CITY OF ALBUQUERQUE

January 3, 2017

**Re: Bombs Away Beer Co.
9801 Acoma Rd. SE
Traffic Circulation Layout
Architect's Stamp dated 12-23-16 (L20-D070)**

A1.2

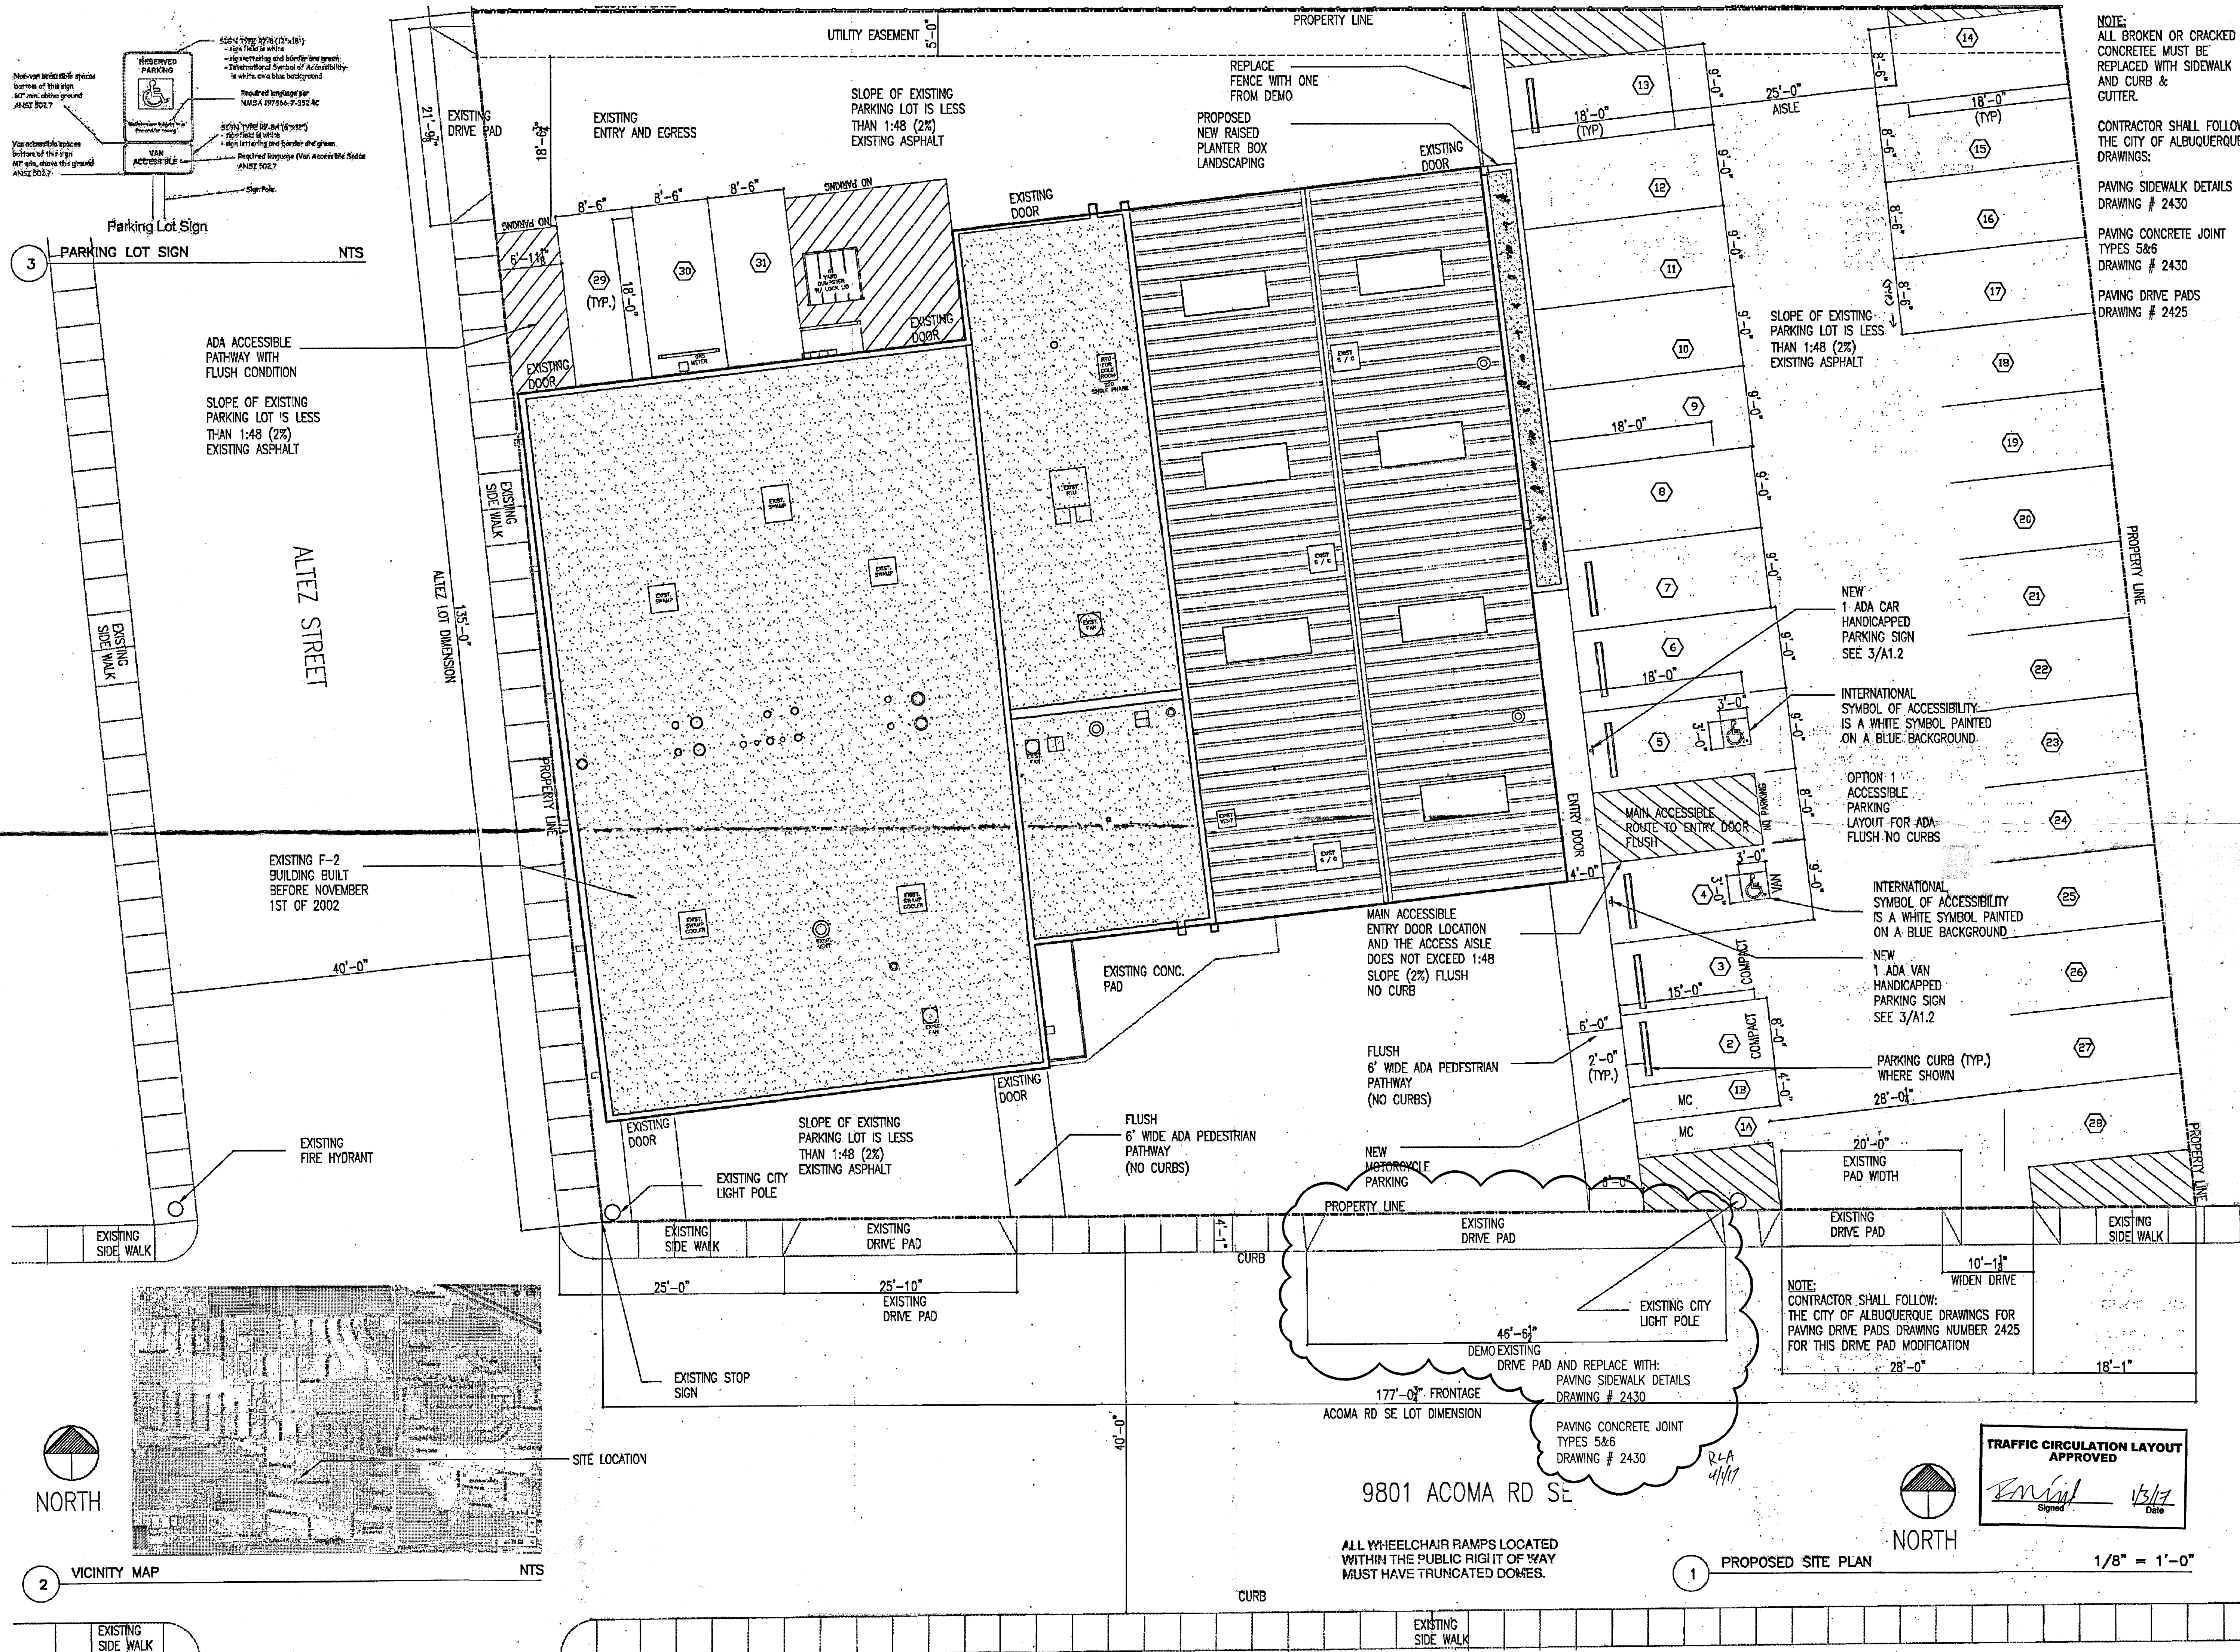
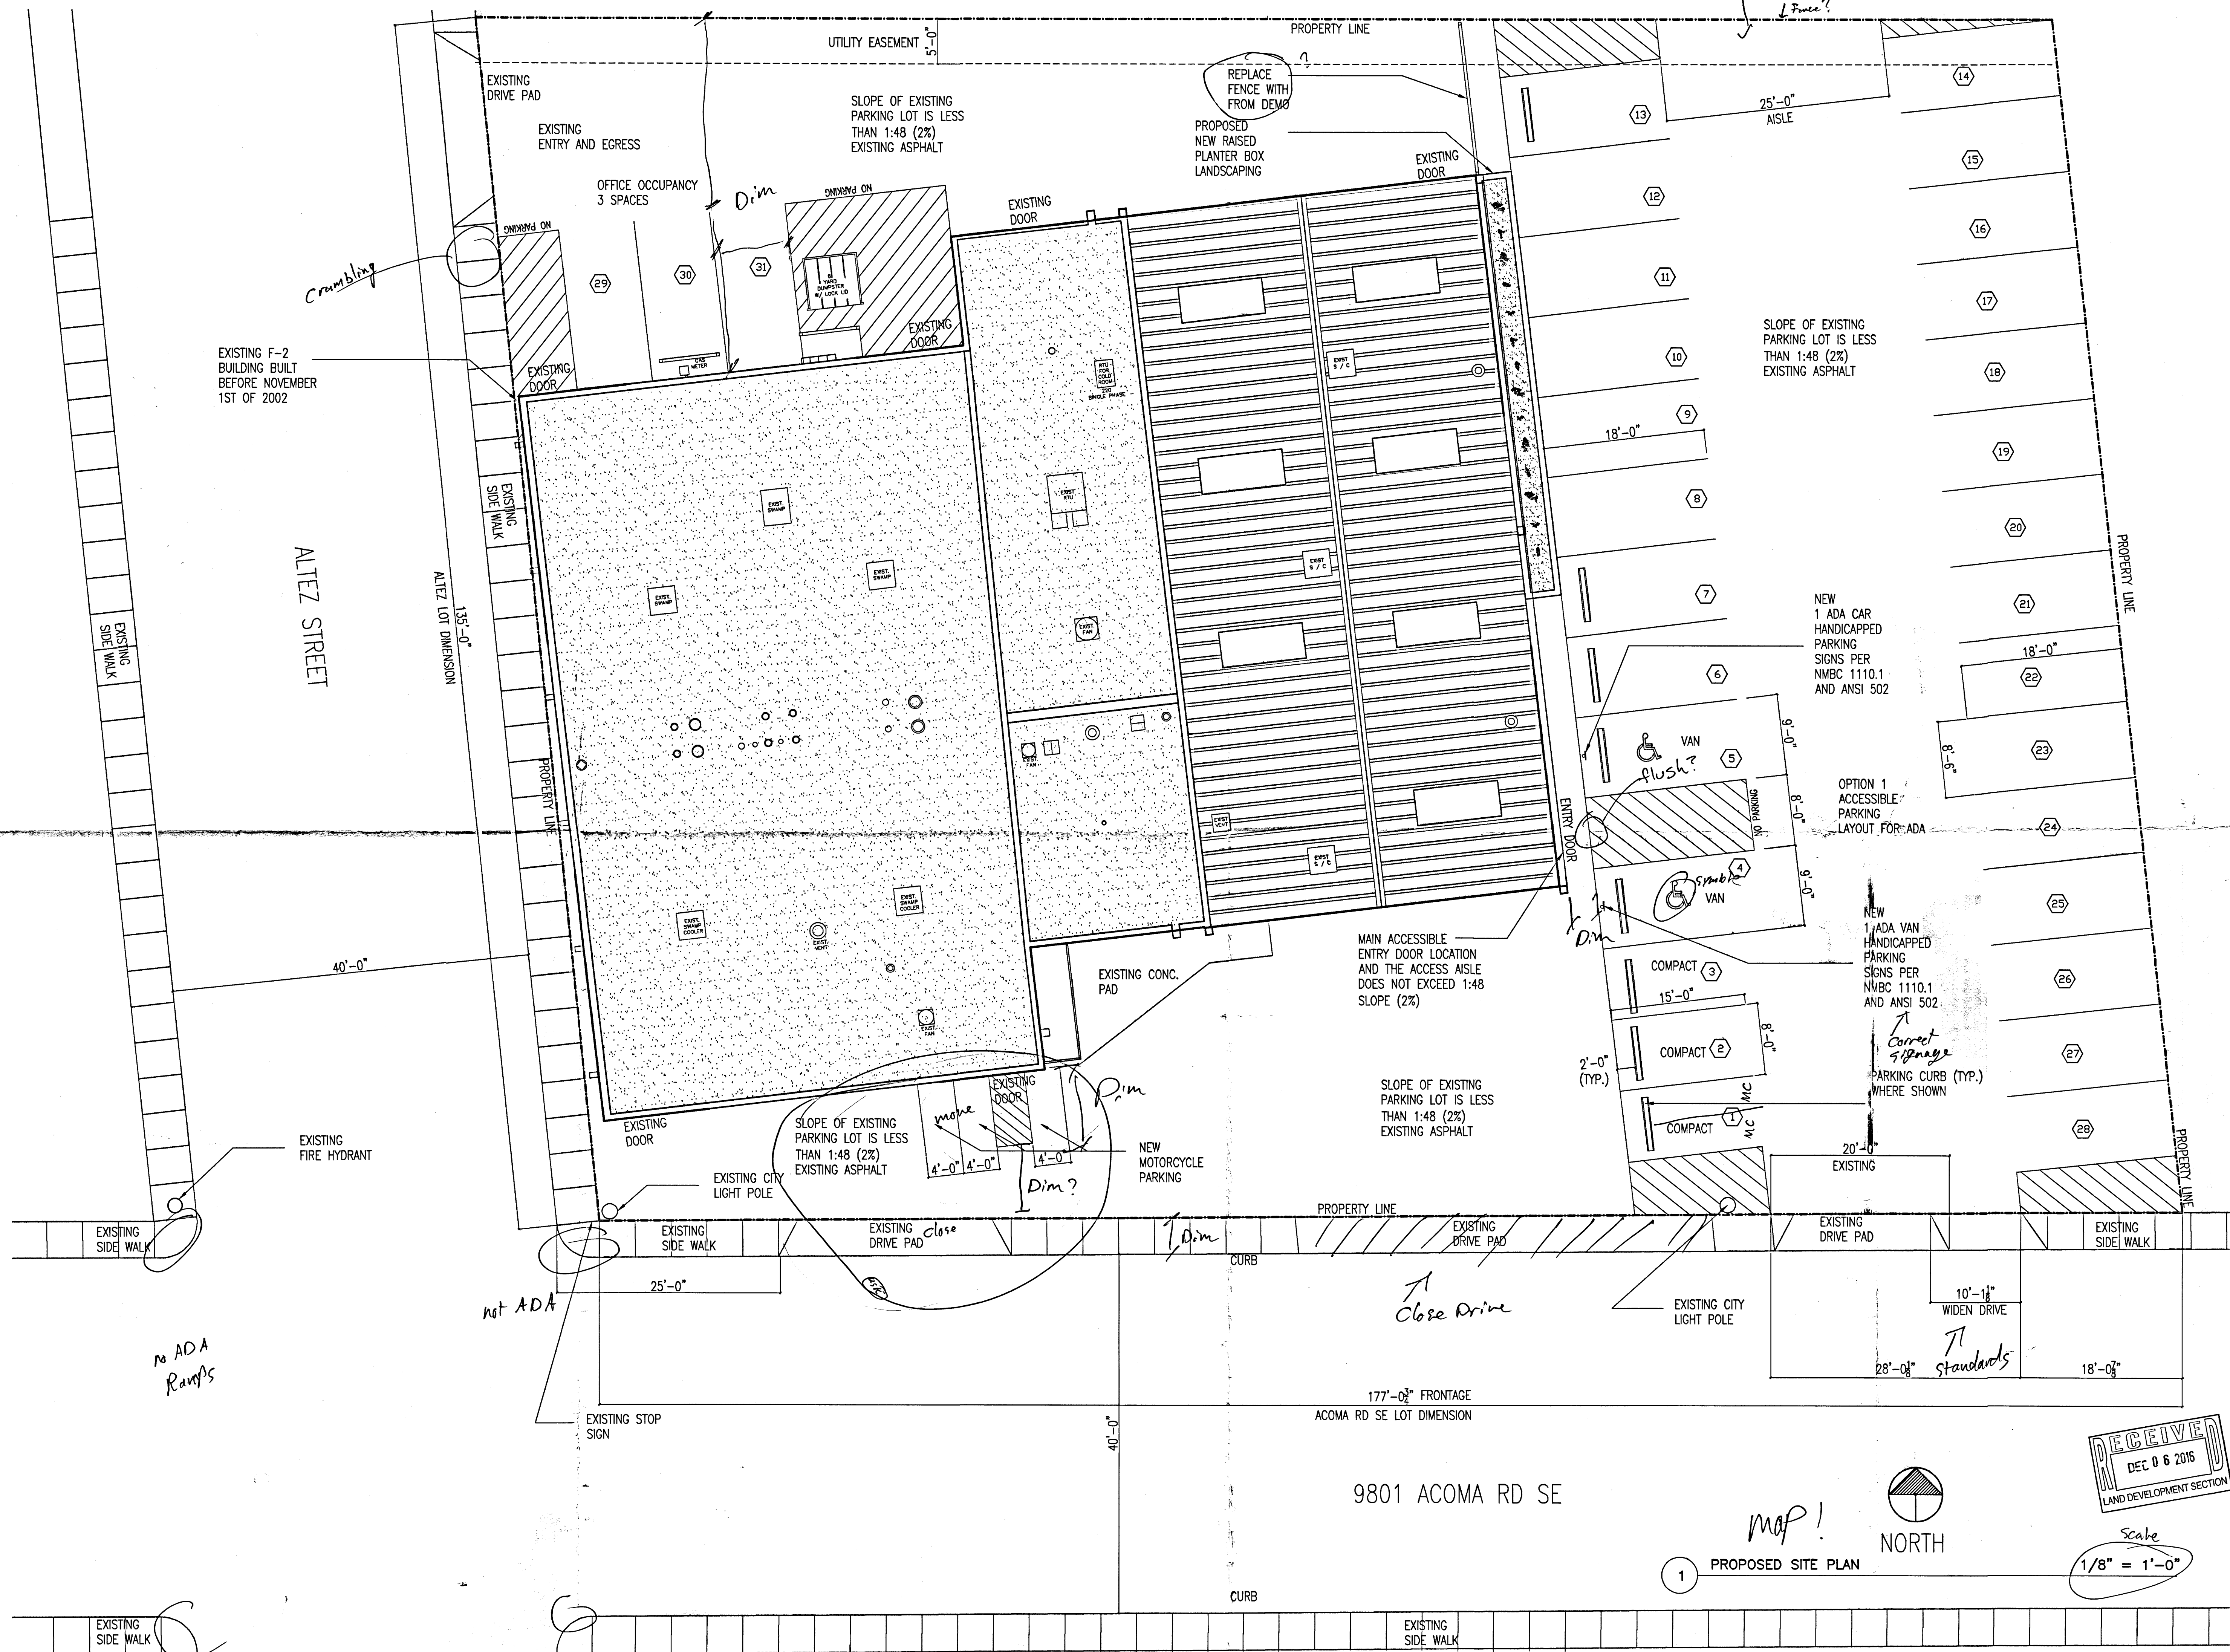
I was able to look at the resubmittal for the TCL. The two driveways (25' 10" and the 46' 6") on Acoma Rd should be closed with sidewalk (standard drawing 2430) and curb and gutter (standard drawing 2415A). This can be address by a red line if you can have your architect come in and make the changes and add a revision date or they can be changed on the plan and submitted again.

The TCL submittal received 12-29-16 is approved for Building Permit. A copy of the stamped and signed plan will be needed for each of the building permit plans. Please keep the original to be used for certification of the site for final C.O. for Transportation.
